From: 
Sent: Tim Murray 
To: 30 January 2015 16:42
Subject: Janice Chapman
Re: FP/219/14/HH - Ground & First floor extensions and loft conversion at 1 First Avenue, Felpham
Attachments: First Avenue 1-Layout4.pdf

From: Janice Chapman
Sent: Friday, January 30, 2015 12:28 PM
To: 
Subject: FP/219/14/HH - Ground & First floor extensions and loft conversion at 1 First Avenue, Felpham

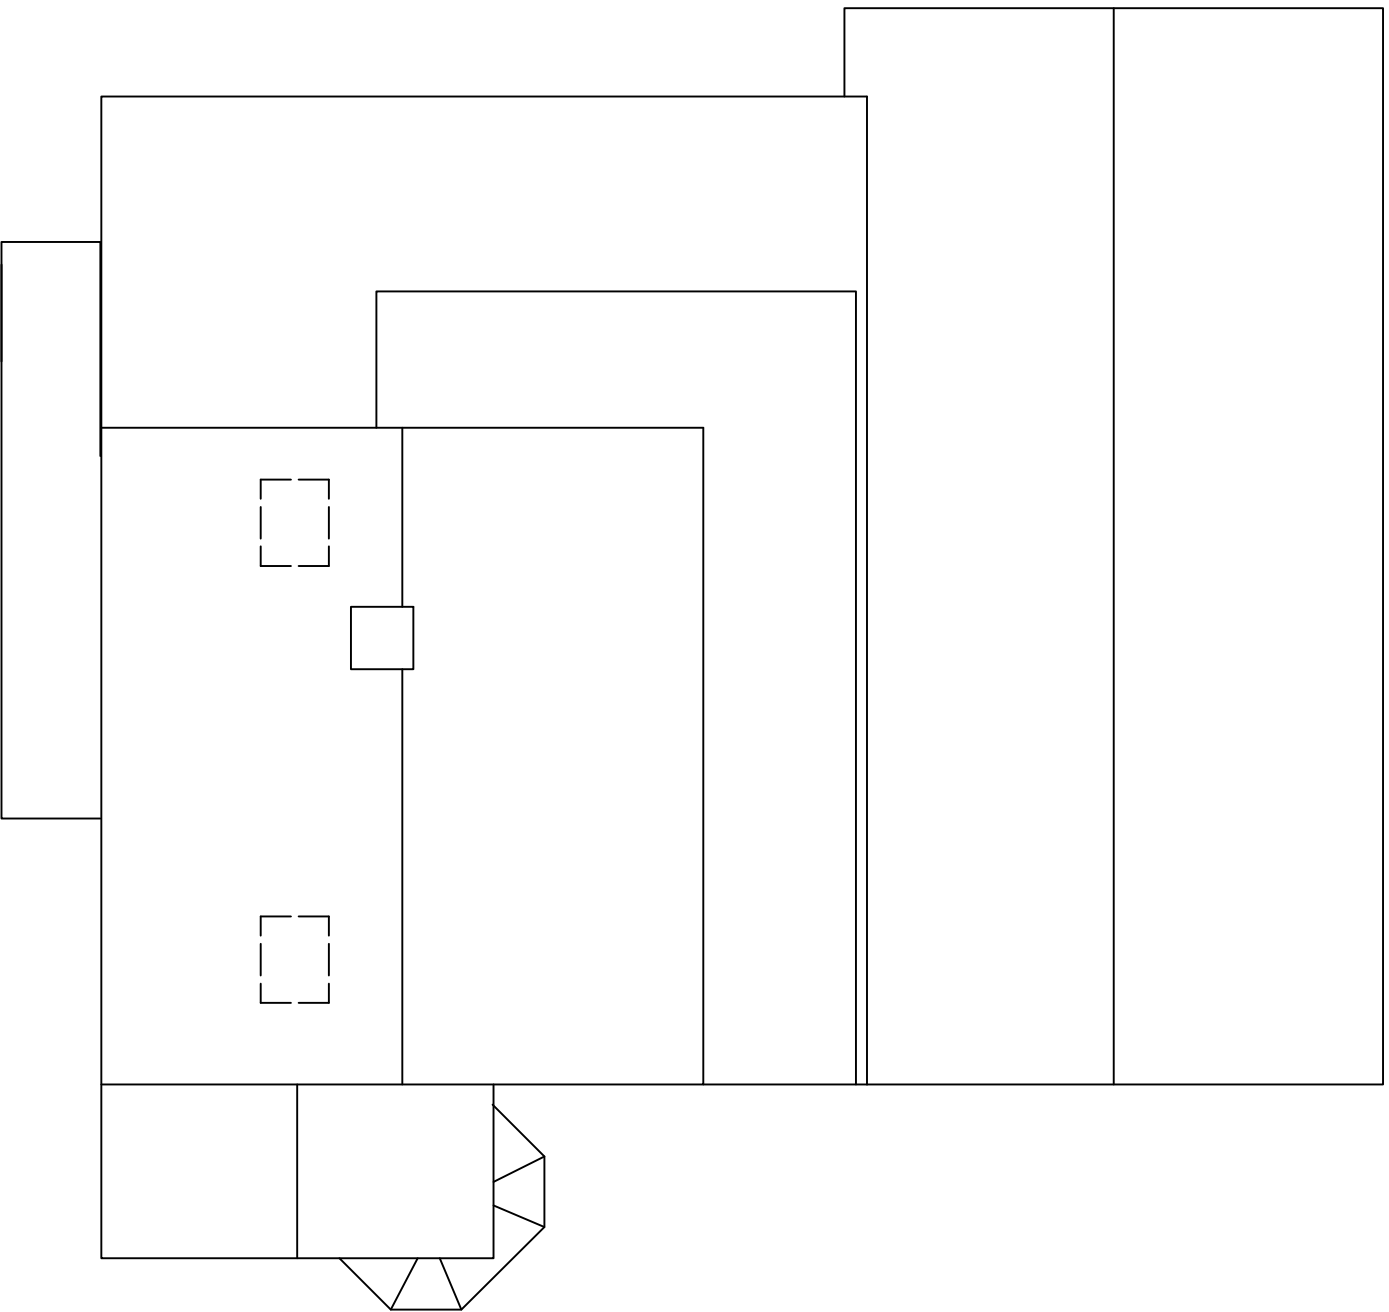
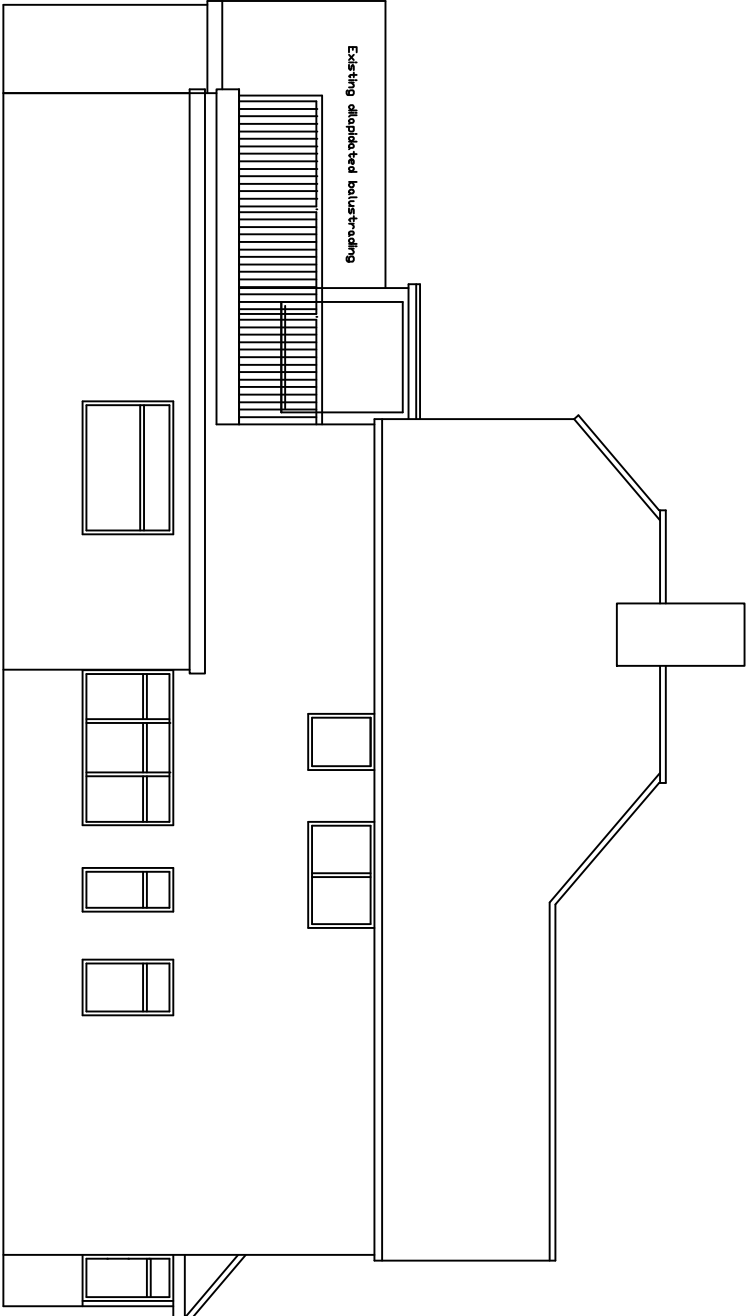
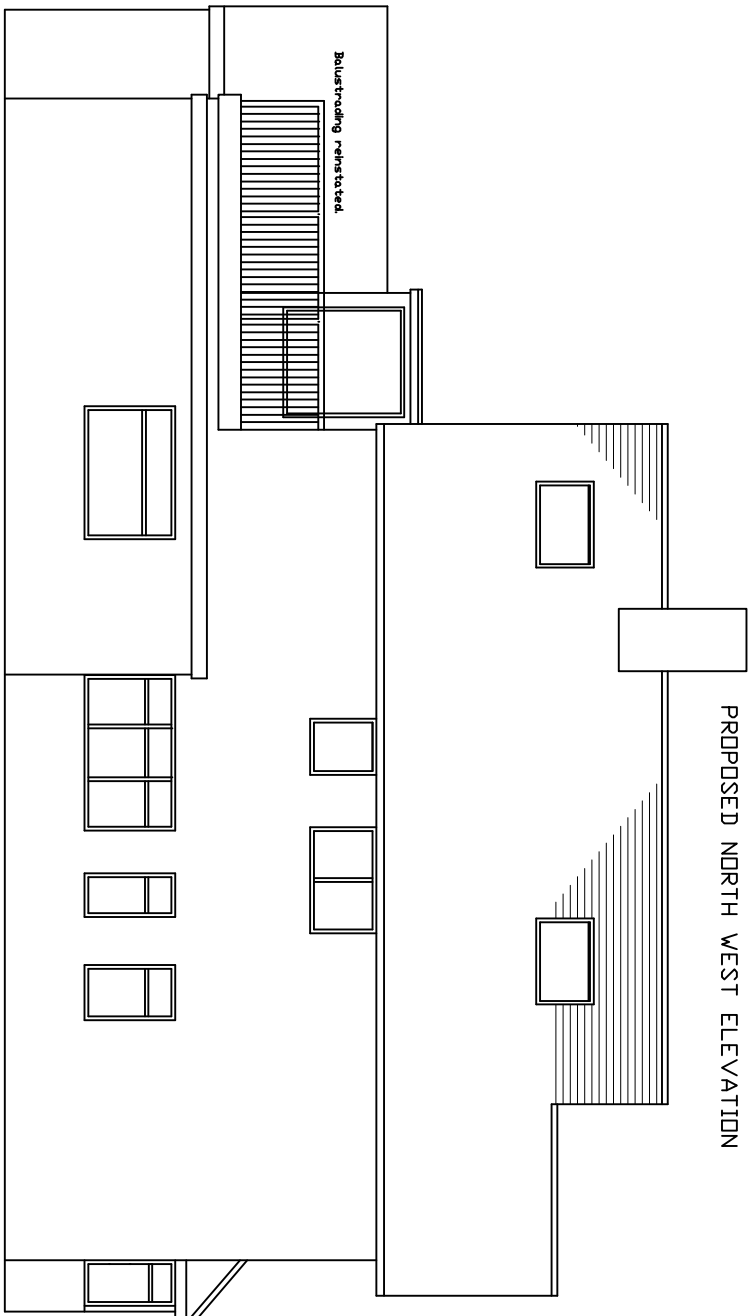
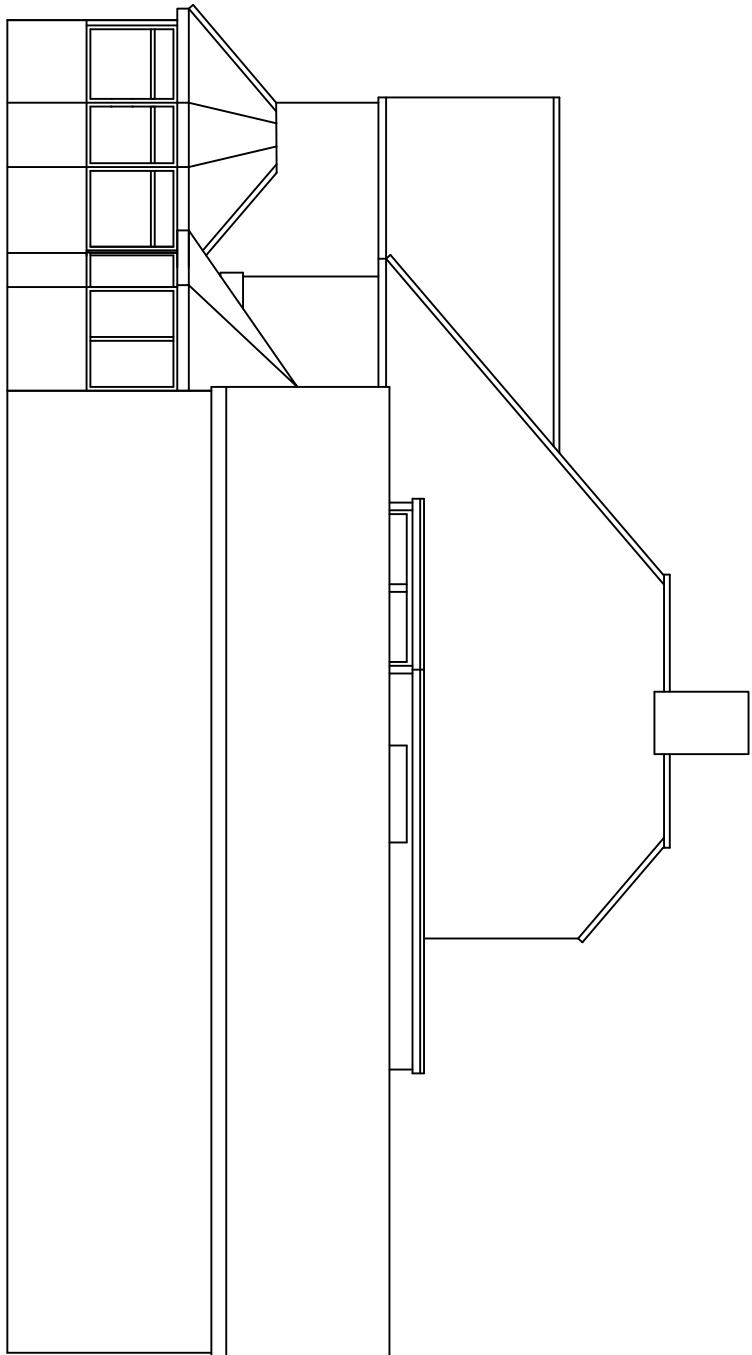
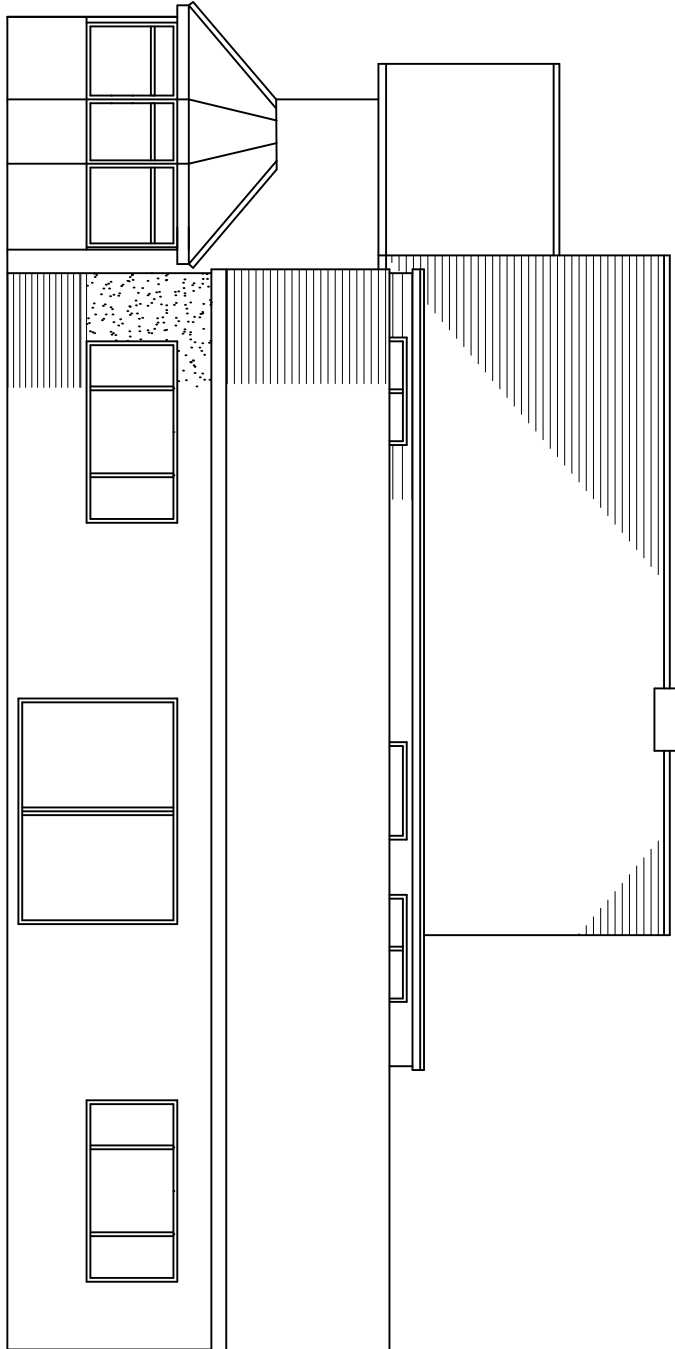
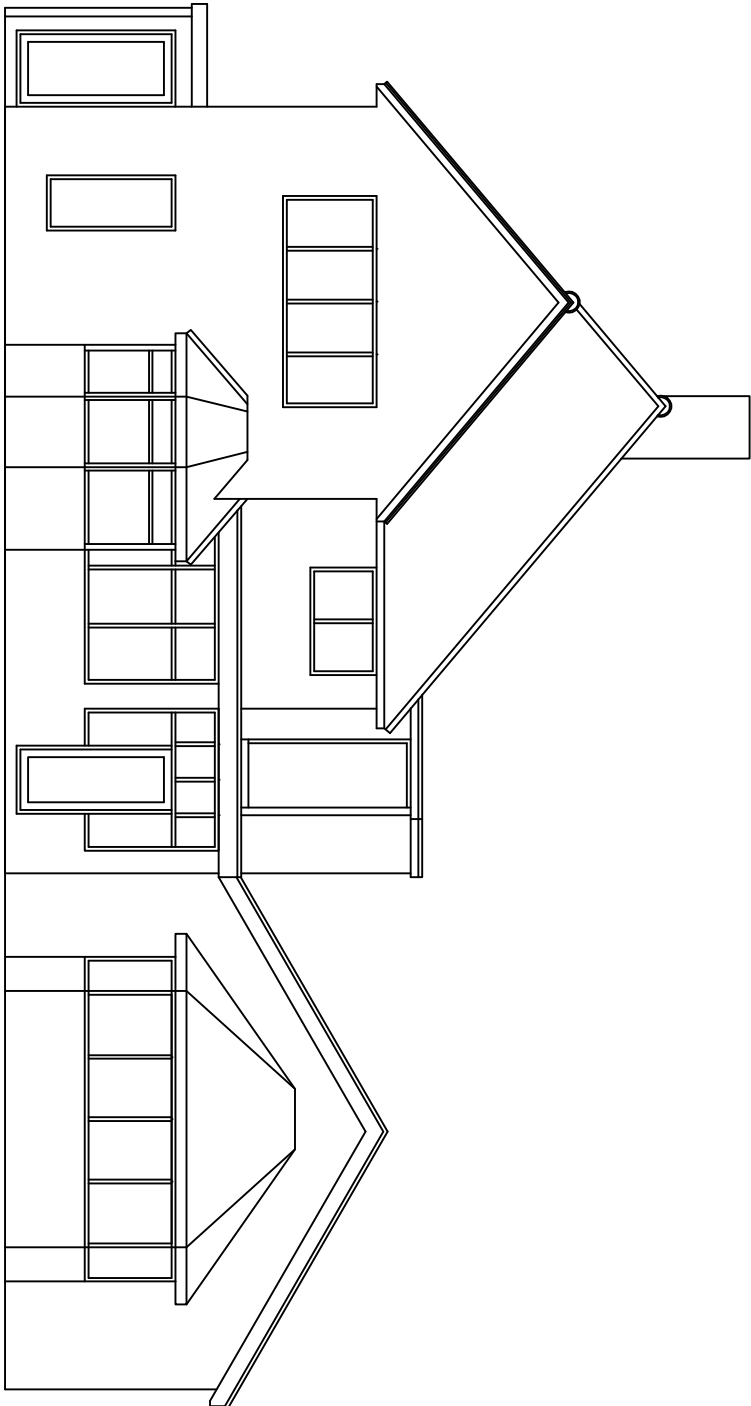
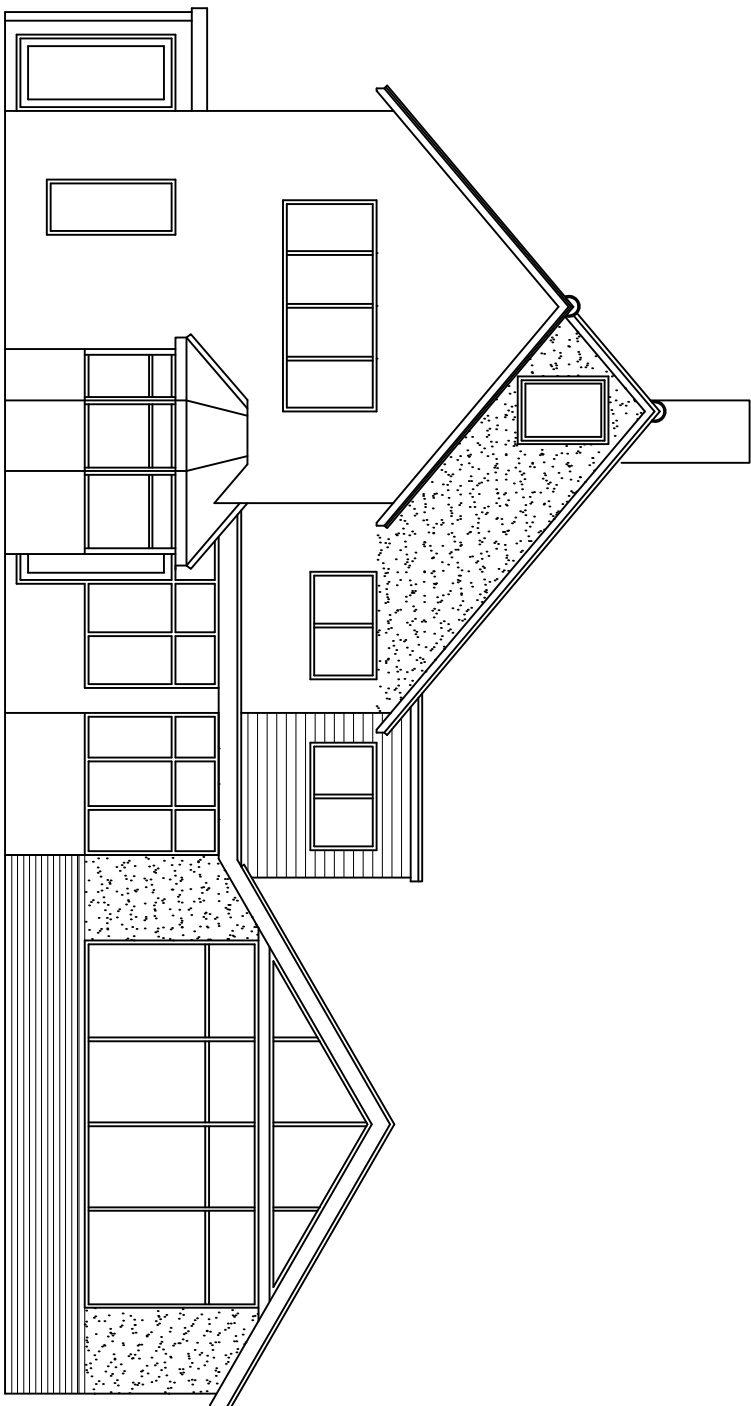
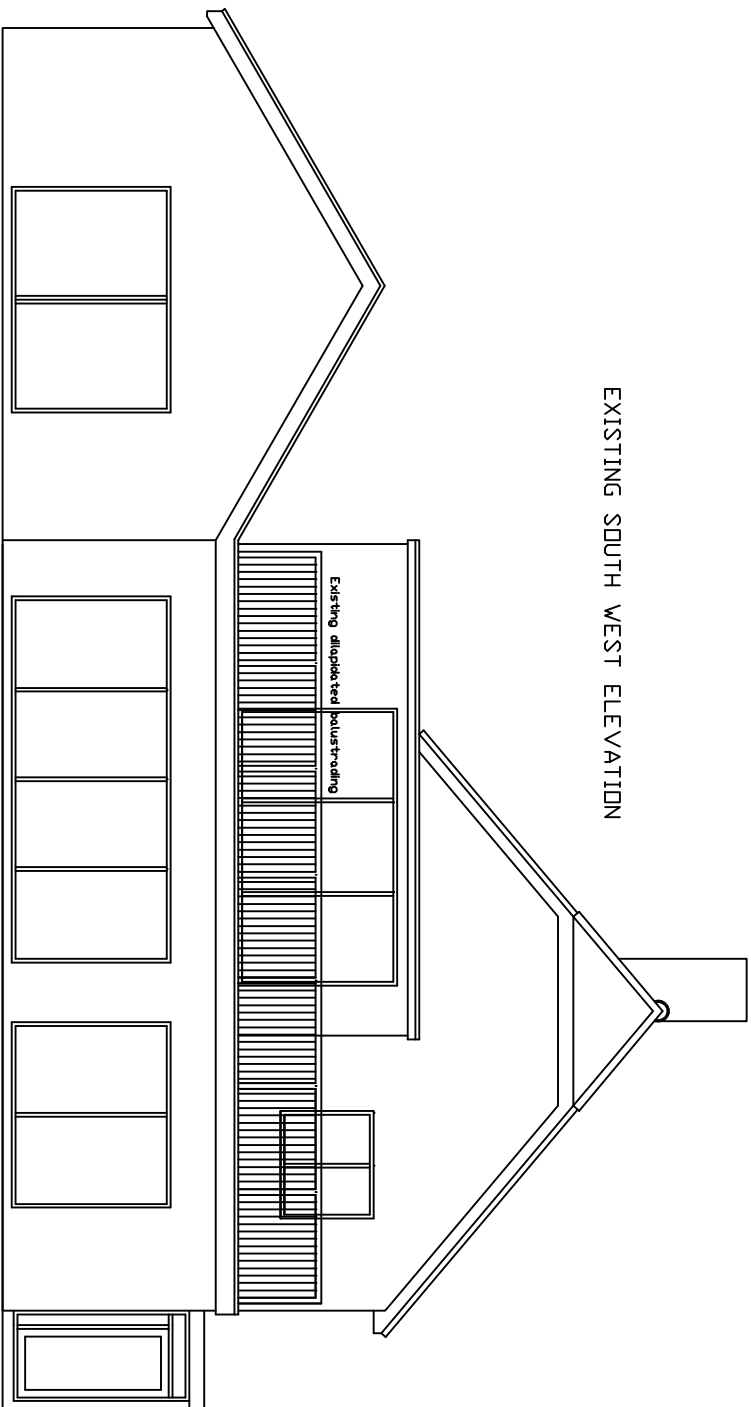
From a site visit the submitted elevations appear to be incorrect. The front elevation facing First Avenue is north west should be south west, etc. Can you please amend.

Amended plans attached.
